MEMORANDUM

July 14, 2016

Re: Additional Plants for the Luedke Landscape Remediation Plan

Luedke Residence - Remediation Plan

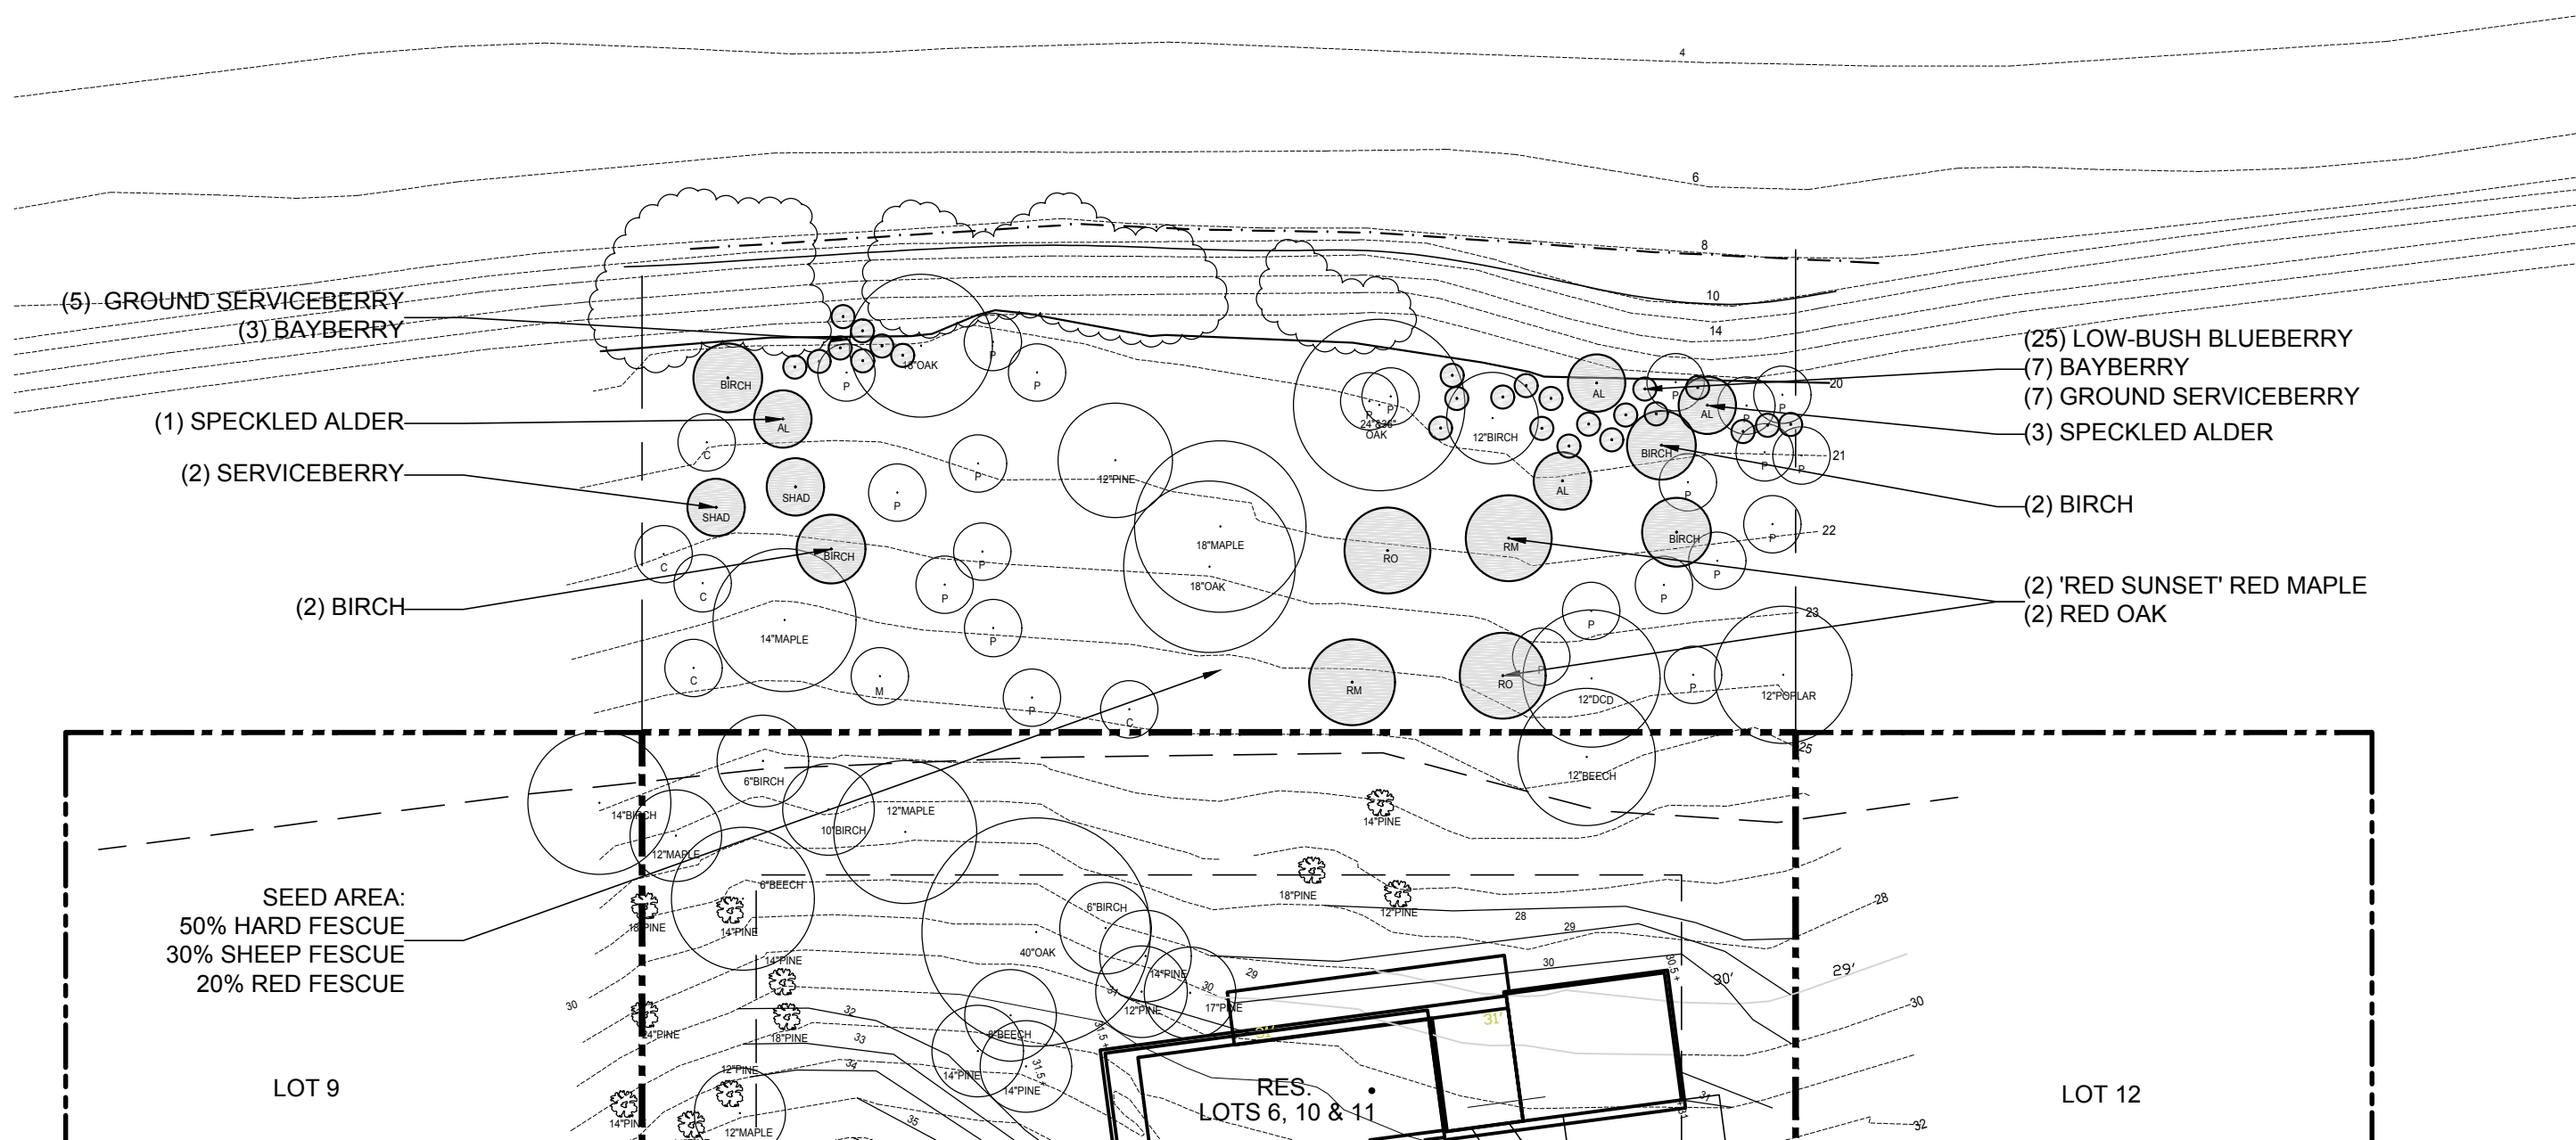
In response to the email I received yesterday from you, where in you requested that the remediation plan planting for the right-of-way be increased by and additional 50-100 native shrub plantings, I offer the responses below for your review. These plantings will be in addition to the plant list set forth in the previously submitted remediation plan.

2. We are proposing to use Bayberry, Black Chokeberry, and Huckleberry for shrubs, and to use Hayscented Fern as a ground cover. We have verified availability for all of these plant materials from a local nursery and the attached plant list reflects the sizes available and quantities noted on the plant list. A total of 58 shrubs and 40 Hayscented Fern are proposed to be distributed through the disturbed area.

3. These additional plantings will be placed in small groupings of 2 to 5 shrubs and accompanied with 5 to 8 of the Hayscented Ferns. These plantings will conform to the guidelines and recommendations set forth in the previously submitted recommendation plan.
